ATTACHMENT A – DETAILED RESPONSE TO SUBMISSIONS TABLE

Table 1 – Record and response to submissions to SSD 10822510

7 June 21 - 3pm
CD305 SCALE: 1 : 2000

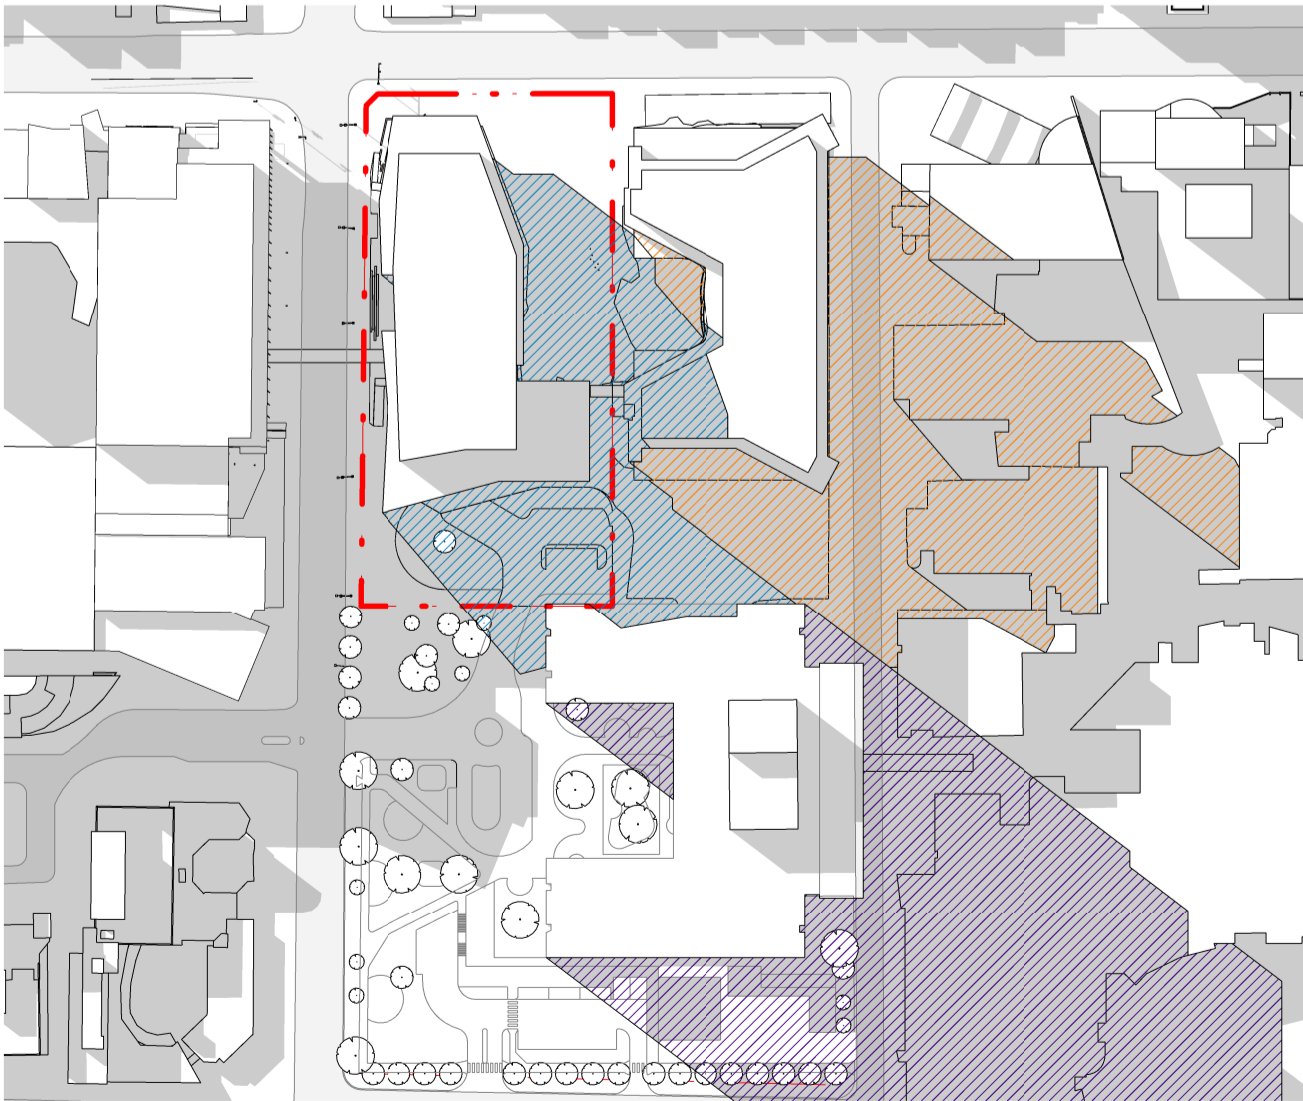
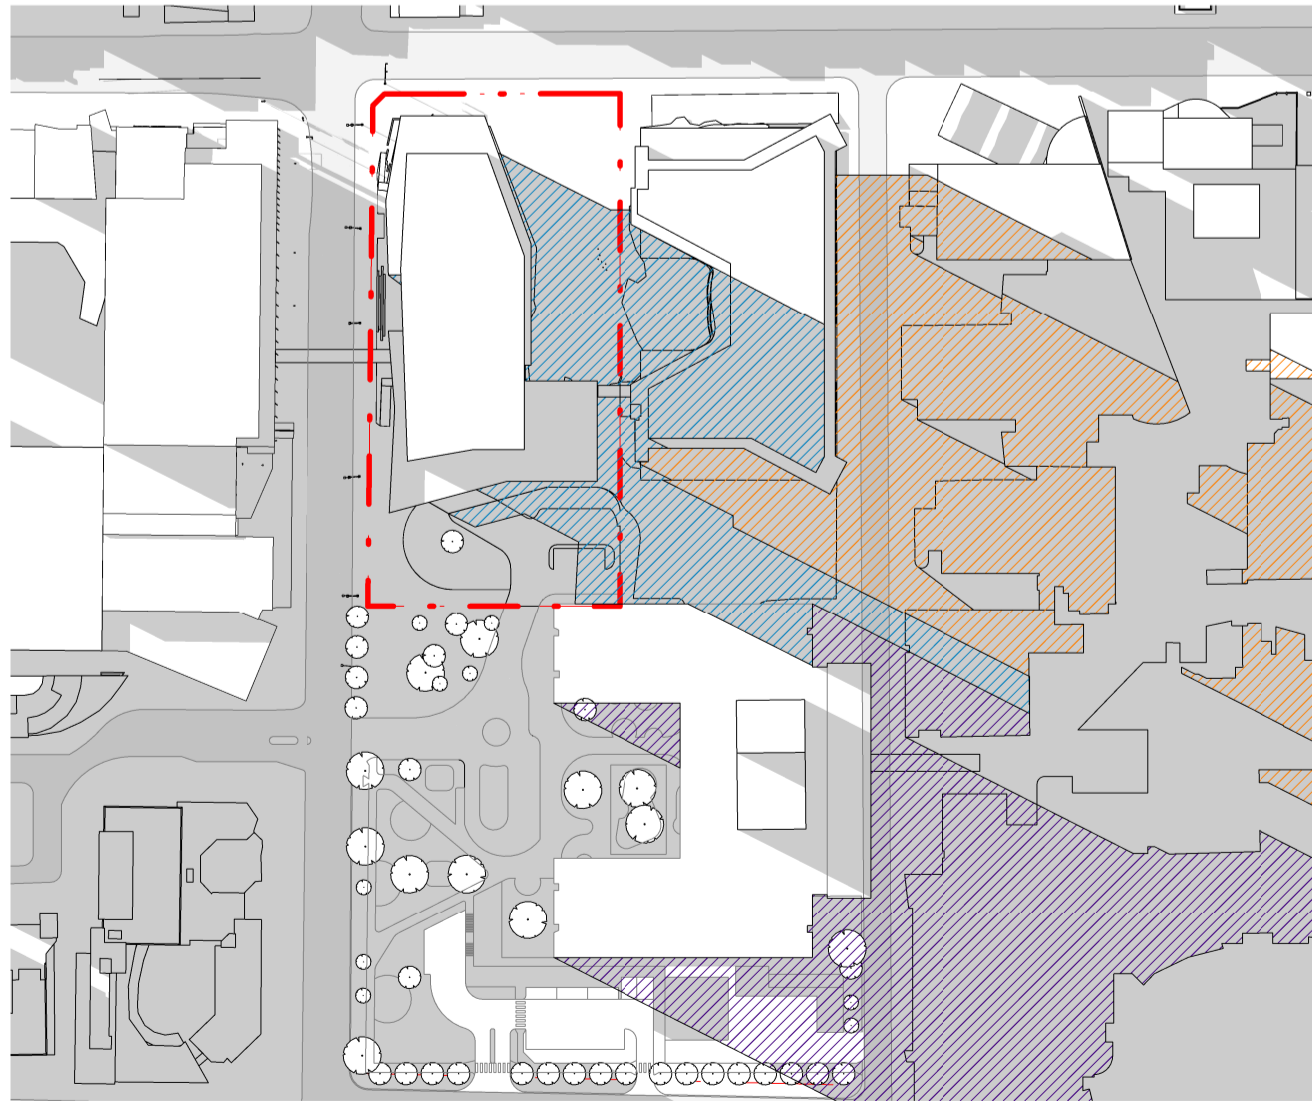
17			<i>It appears that the current southern leg of the UNSW HTH building will overshadow the Children's Hospital emergency vehicular drop off loop and pedestrian waiting area, as currently configured, for most of winter months.</i>	<p>Overall, the shadow diagrams demonstrate that:</p> <ul style="list-style-type: none"> At all times of the day on the Winter Solstice, the IASB will overshadow all or part of the U-shaped space at the entry to the IASB (the IASB entry forecourt); Between 10am and 3pm on the Winter Solstice, parts of the hospital access area and vehicular drop-off / pick-up will receive some solar access. There are significant areas of solar access available between 12pm – 2pm; and From 2pm onwards, existing buildings on the UNSW Kensington Campus will overshadow all or part of the IASB forecourt and hospital access area and vehicular drop-off / pick-up.
18			<i>The shadow diagrams provided are limited, addressing only the early morning, midday and late afternoon. Hourly shadow diagrams at the June 21 should be provided to assess solar access and amenity.</i>	<p>With respect to the impact of the UNSW HTH, the shadow diagrams demonstrate that:</p> <ul style="list-style-type: none"> The UNSW HTH will have a minimal impact on the IASB entry forecourt; The UNSW HTH will overshadow parts of the hospital access area and vehicular drop-off / pick-up between 9am and 12pm on the Winter Solstice, however shadows are largely limited to the access roads and circulation spaces; and From 1pm onwards, the UNSW HTH will have a limited impact on the hospital access area and vehicular drop-off / pick-up.

Item No	Name	Type	Issue	Response
				Based on the above, it is considered that the overshadowing impacts associated with the UNSW HTH are acceptable. Despite the UNSW HTH, parts of the hospital access area and vehicular drop-off / pick-up will receive solar access between 10am and 3pm on the Winter Solstice, providing opportunity for visitors to find areas of sunlight, if desired. Further, as part of the UNSW HTH, a large, north-facing publicly accessible plaza will be provided which will receive ample solar access on June 21.
19			High Street frontage street wall datum <i>The UNSW HTH building along the northern High Street frontage is eight storeys which maintains the emerging seven to eight storey street wall height along this street frontage. The 6m ground level setback and the additional upper level tower setback of approximately 9.6m is supported, as it will reduce the apparent tower building height and help to mitigate the potential scale impacts upon the High Street streetscape.</i>	Noted.

Foundation Plan – Illustrating proximity of structure to the light rail

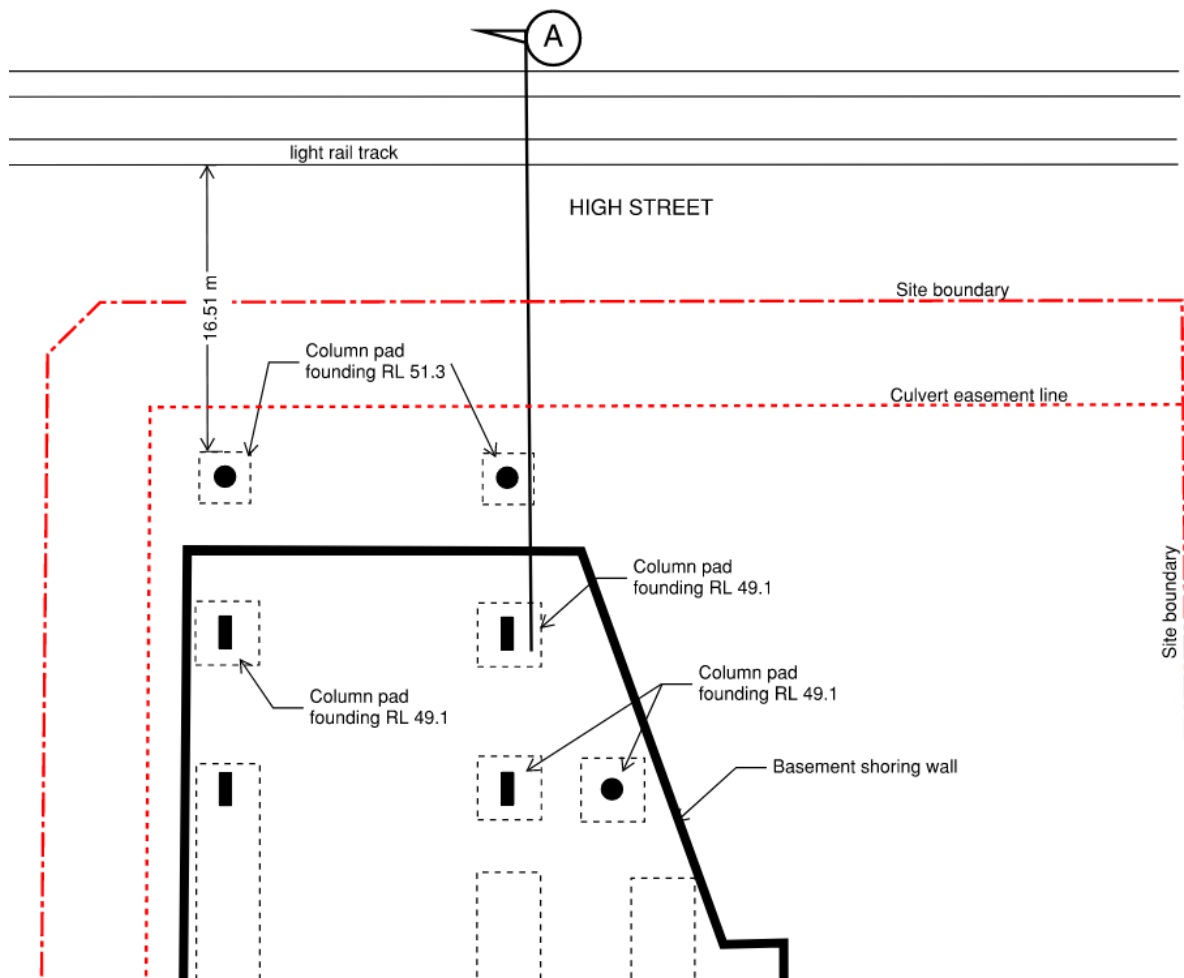
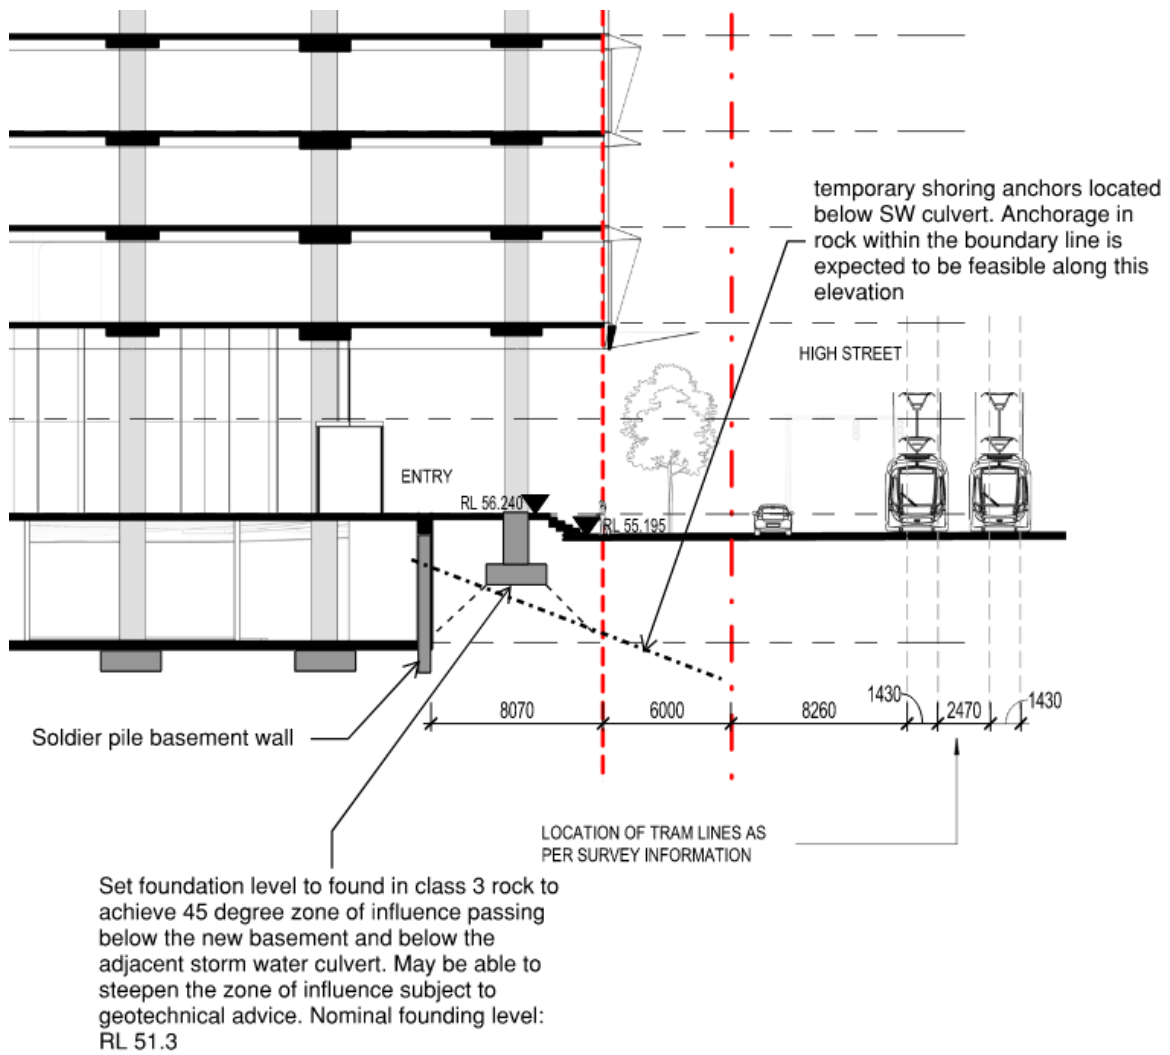
54	Transport for NSW (TfNSW)	Comment	<p>Protection of TfNSW Infrastructure and Sydney Light Rail Operation</p> <p><u>Comment</u></p> <p><i>The development includes a proposal for the excavation, construction, and operation of a health facility that is near to the Sydney Light Rail corridor.</i></p> <p><i>There are concerns about the potential effect on the structural integrity and safe operation of the light rail during construction and operation phases of the development. The proposed development is located within 25m of the light rail corridor. Clause 86 of the State Environmental Planning Policy (Infrastructure) (ISEPP) outlines that in this circumstance development would require concurrence from TfNSW.</i></p>	Noted. Further advice has been prepared by Arup (Attachment F) to detail the proposal's impact and location in relation to existing Light Rail infrastructure.

Item No	Name	Type	Issue	Response
			<p><i>As the proposal is being assessed as State Significant Development, formal concurrence from TfNSW does not apply. Nevertheless, the development has been assessed and appropriate mitigation measures should be adopted to minimise these effects.</i></p> <p><i>The light rail infrastructure must be protected and any disruptions to its operation are to be minimised during the construction and operation of the subject development.</i></p> <p><i>It is advised that the applicant needs to assess the impacts of the operation of the Sydney Light Rail on the future locations of sensitive equipment (if any) within the subject site, particularly in regards to Electromagnetic Interference and Vibration and design the development to mitigate potential impacts of the Sydney Light Rail.</i></p>	
55			<p><u>Recommendation</u></p> <p><i>It is advised that the applicant must provide detailed engineering drawings, which illustrate the delineation of the light rail tracks (and relative dimensions to the excavation area) as part of the response to submissions.</i></p> <p><i>The applicant must be conditioned to:</i></p> <ul style="list-style-type: none"> <i>Provide all relevant documentation as requested by TfNSW for review and endorsement prior to issuing the relevant Construction Certificate; and</i> <i>Protect TfNSW infrastructure and to minimise disruption to the light rail operation during the construction and operation of the subject development.</i> 	The condition requirements are considered acceptable. Detailed engineering drawings are also proposed to form a condition of development consent. Advice from Arup (provided at Attachment F) outlines the proposal's proximity (structure, sub-structure and temporary shoring anchors) to the Light Rail infrastructure and indicates that the proposed HTH basement shoring, and foundations will impose negligible influence on the existing Light Rail infrastructure.

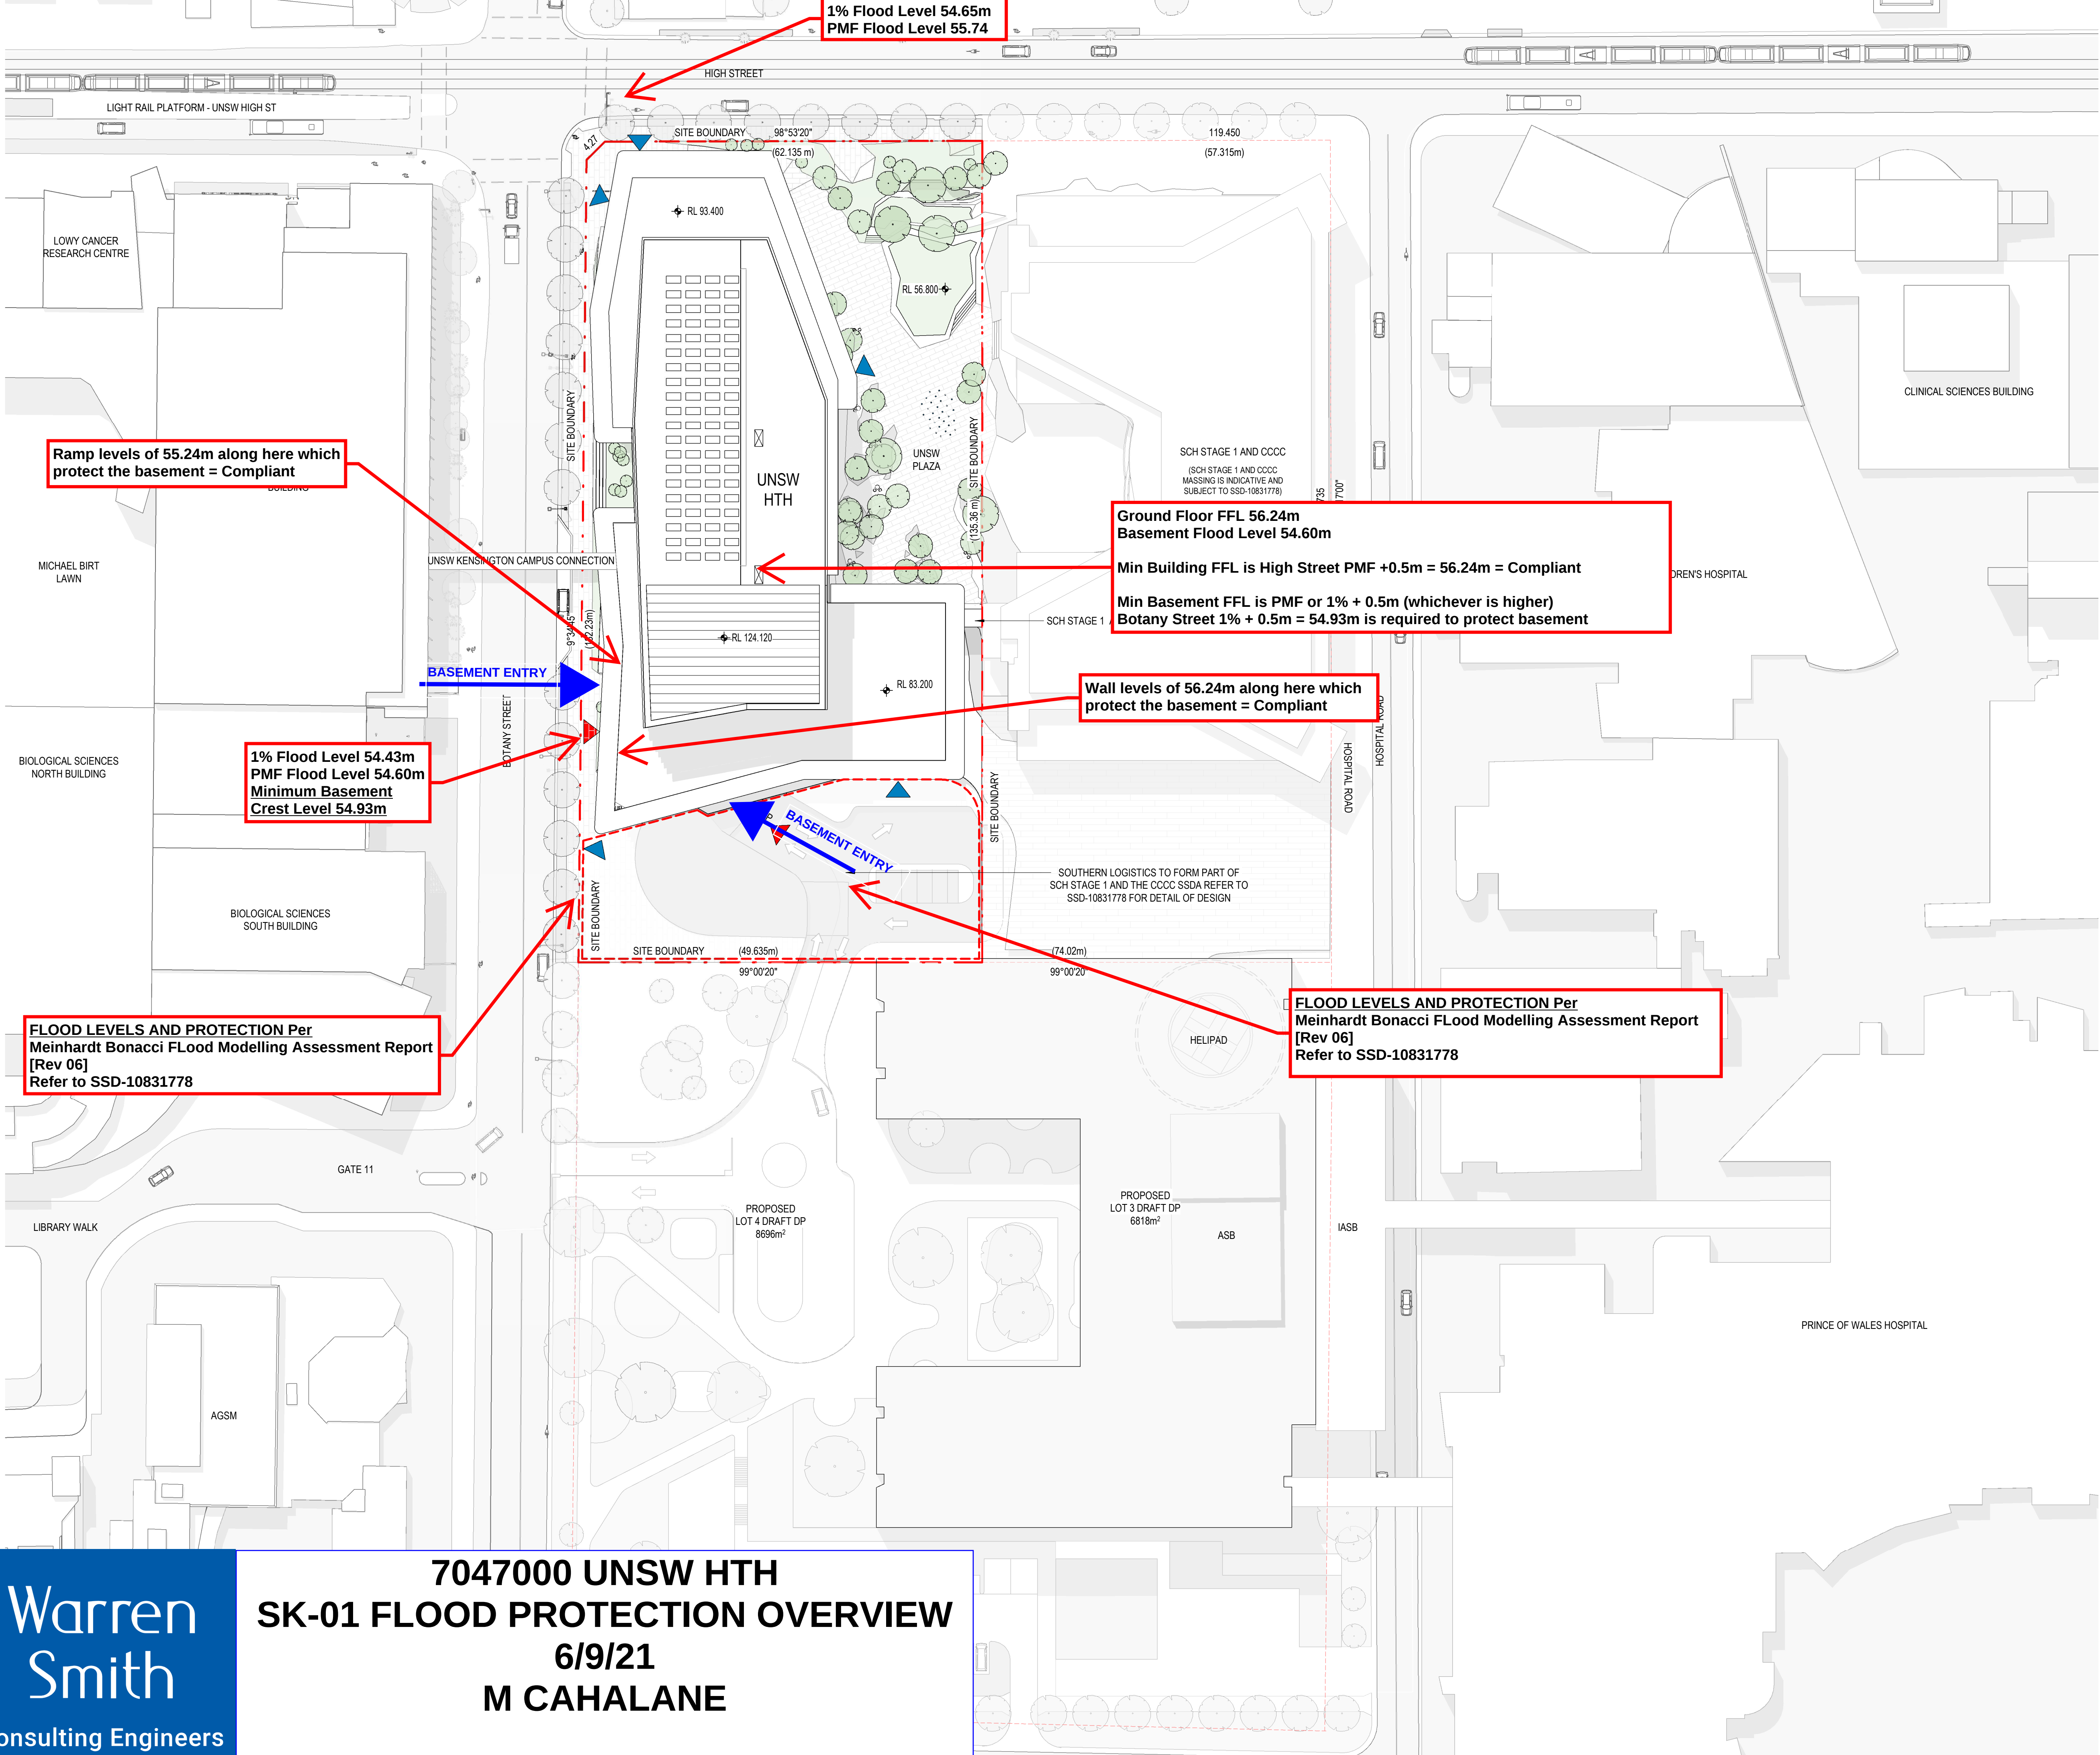
9	DPIE	Comment	Floodplain Risk Management <i>The new university building meets the requirement to have a ground floor level at 500mm above the probable maximum flood (PMF) which has a depth of up to 1.4m in High Street. The building wall below the PMF must be designed to achieve the following in the PMF event:</i> <ul style="list-style-type: none"> • be watertight • resist hydrostatic pressures 	<p>Arup (at Attachment F) and Warren Smith and Partners (Attachment I) has provided further detail on the proposed basement and how it will withstand flooding under PMF or 1 in 100 flood conditions. Specifically, it is noted that:</p> <ul style="list-style-type: none"> • The proposed basement is protected from flooding to the PMF and 1% plus 500mm levels by virtue of: <ul style="list-style-type: none"> – Protection of entry at Botany Street frontage with a ramp crest of RL 55.24m with a 1% plus 500mm level of 54.93m and a PMF level of 54.60m.

Item No	Name	Type	Issue	Response
			<ul style="list-style-type: none"> withstand the impact of likely debris, such as floating cars accommodate predicted scour, and withstand buoyancy and drawdown forces, if applicable. <p>A basement is proposed for the loading dock, bicycle storage and plant. The proponent must describe how the basement is protected from flooding at the PMF level or 1% annual exceedance probability event level plus 500mm freeboard.</p>	<ul style="list-style-type: none"> Protection of basement entry ramp from the south as presented in the Meinhardt Bonacci 'Flood Modelling Assessment' (for the SCH Stage 1 and CCCC) which confirms that 'The basement entry off Botany Street is protected by a crest entrance level in the forecourt set at the 1% AEP plus freeboard level. Additionally, please note that the adjacent structural walls of the entry ramp to the basement are to be set at a height above the 1% AEP plus freeboard level'. Given a drained basement is proposed, ground flow water into the basement is to be collected in a sump and pumped from the basement; Basement walls will be designed to resist the hydrostatic pressures and associated draw down forces that are expected during the design flood event; Being a drained basement, the lowest basement floor will be constructed over a drainage layer and may incorporate pressure relief ports if these are determined to be required to protect the floor from buoyancy forces; and The building will have sufficient structural robustness to resist reasonable impact from floating cars and debris in the event of a flood and the building is unlikely to be undermined by scour.
